Application for a non-material amendment following a grant of planning permission.
Town and Country Planning Act 1990

Extensions and alterations to existing property, including new roof terrace.

Resting of the proposed attached double garage.

Old plan/drawing numbers: 1070.02.c Proposed A1

Ground Floor Plan

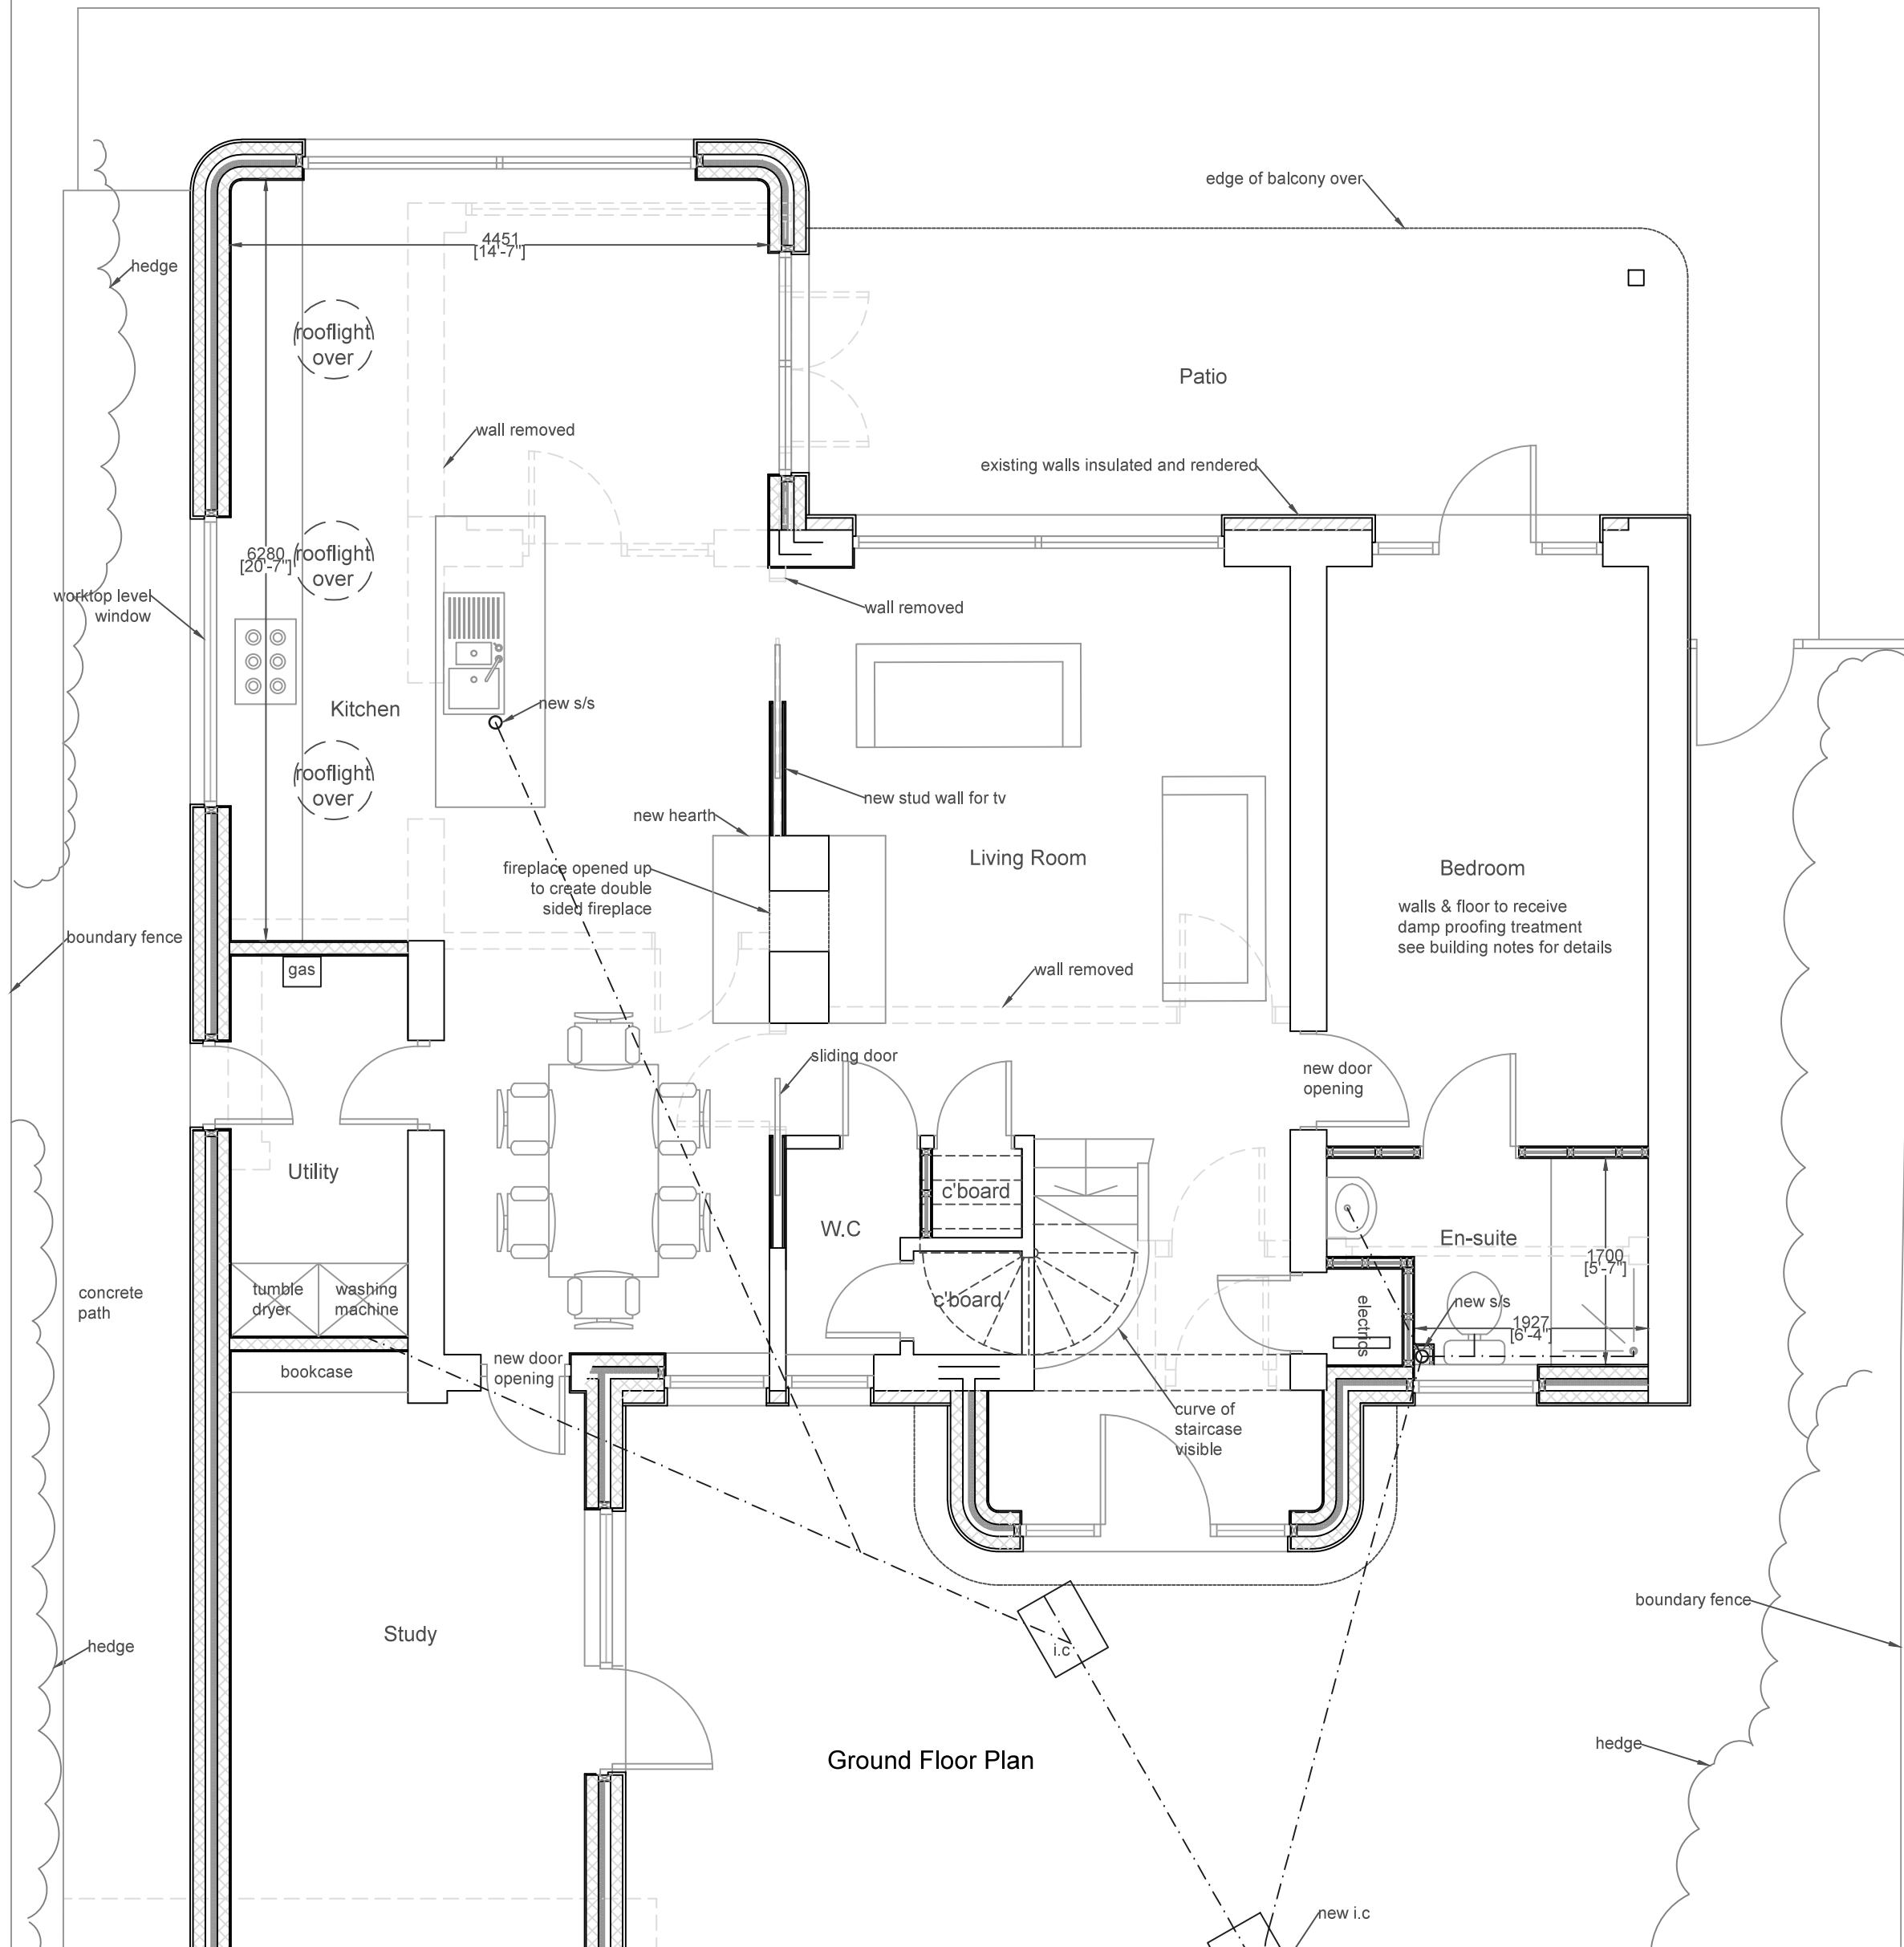
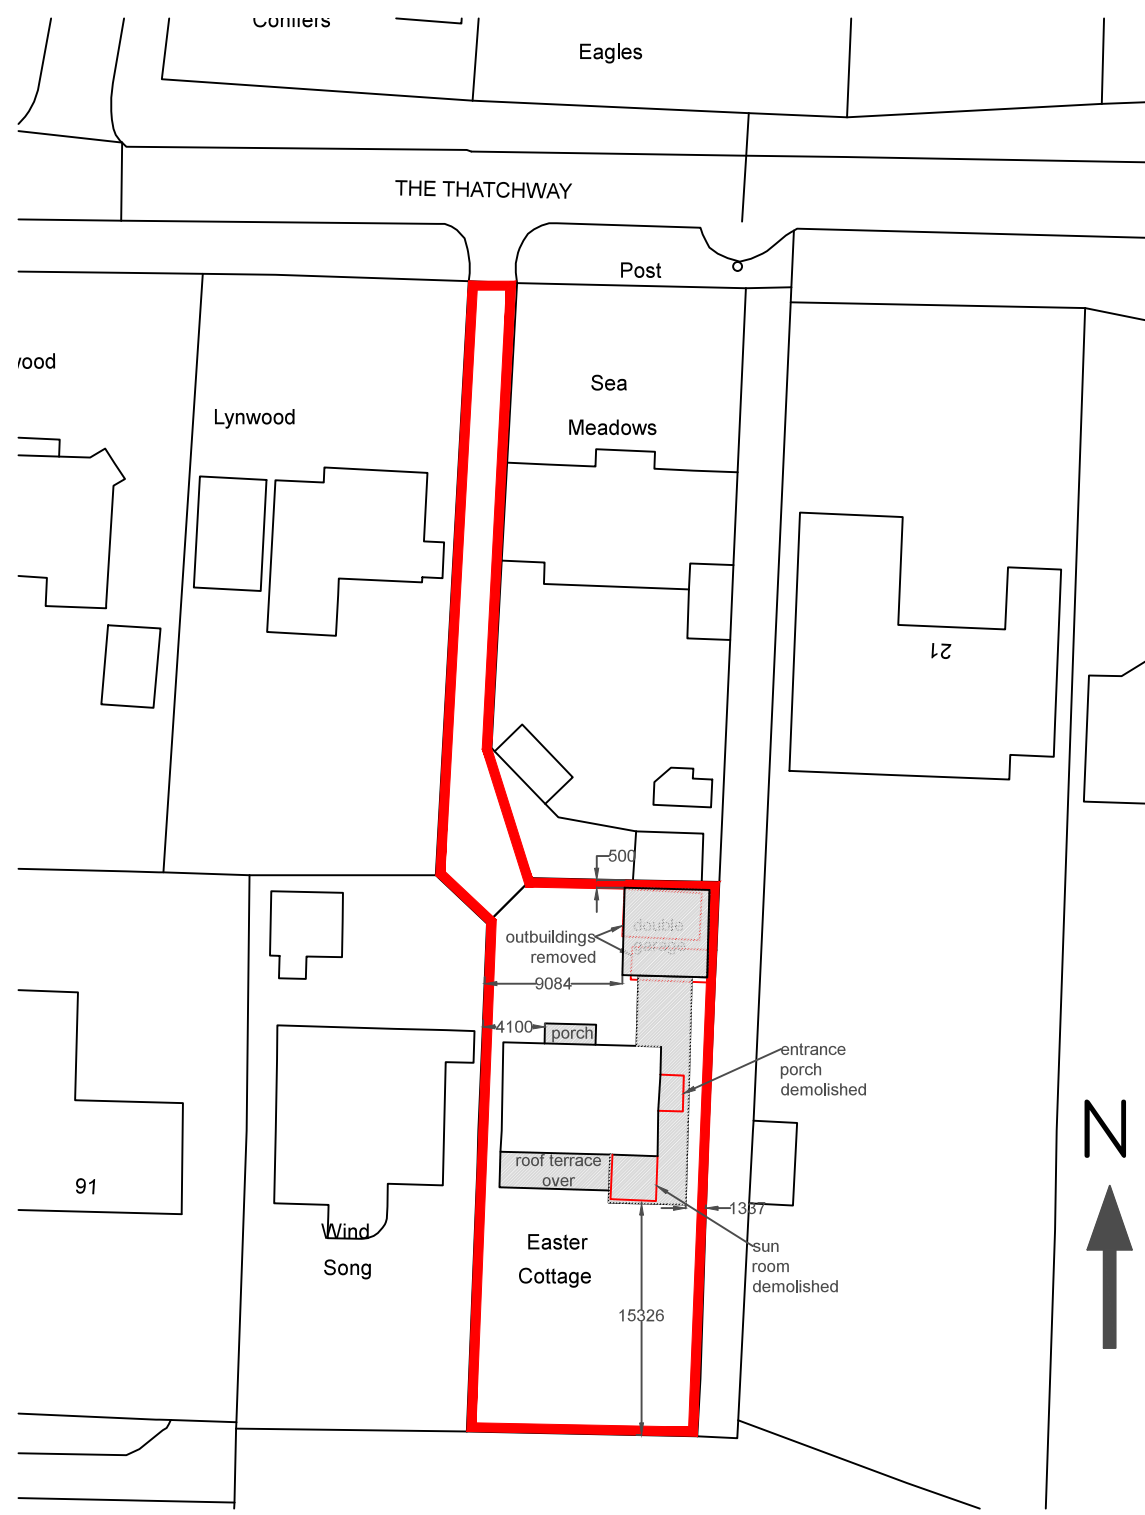
Access behind garage not required and moving the garage gives more space for parking to the front of the property.

New plan/drawing numbers: 1070.02.e Proposed A1
